Ref: 6/2021/2879/FULL
Date: 06/12/2021

HISTORIC BUILDINGS AND CONSERVATION ADVICE

RE: Comet Hotel, St Albans Road West, Hatfield, AL10 9RH

The application is for the installation of wooden post and rope fence to front boundary and installation of wooden gates to service yard.

CLIENT: The Comet Hotel	DRAWING NO: 185-101-A
PROJECT DESCRIPTION: Bin Gates & Boundary Fencing	
PROJECT ADDRESS: The Comet Hotel, St Albans Road West, Hatfield, AL10 9RH	
DRAWING TITLE: Proposed Gate Elevations & Section	
STATUS: PLANNING	SCALE: As noted @A3 DATE: September 2021

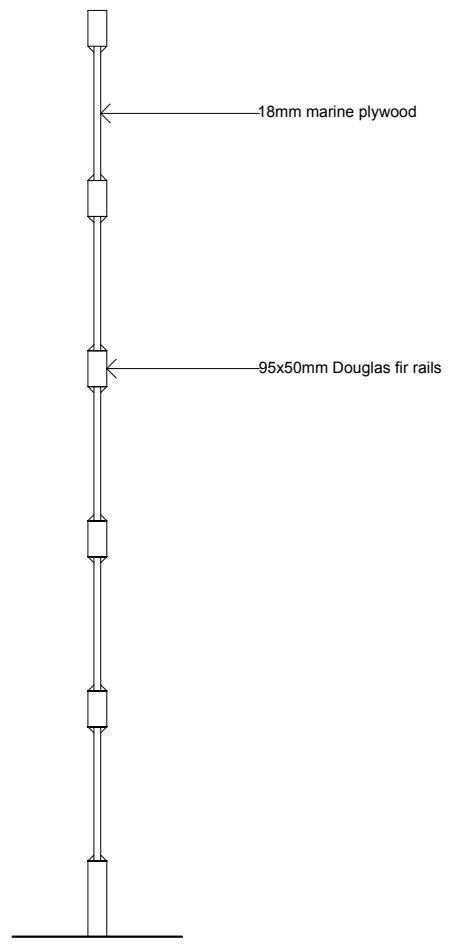
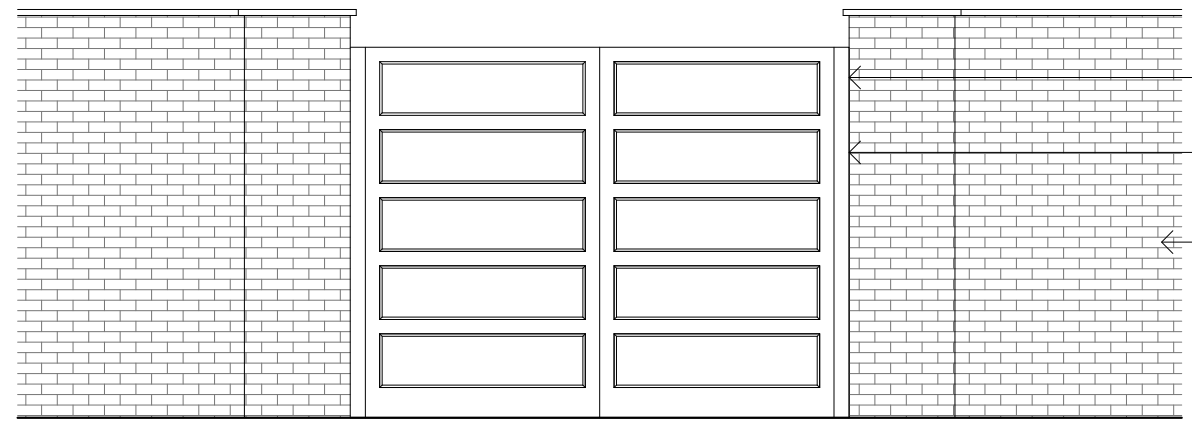
There are no objections to the proposal. The proposed gates to the bin store reinstate former gates of the same design, and also match an existing door to the service yard (photographs provided in the Design and Access Statement). The proposed timber post and rope fence is a simple and visually unobtrusive design which will not detract from the setting of the listed building.
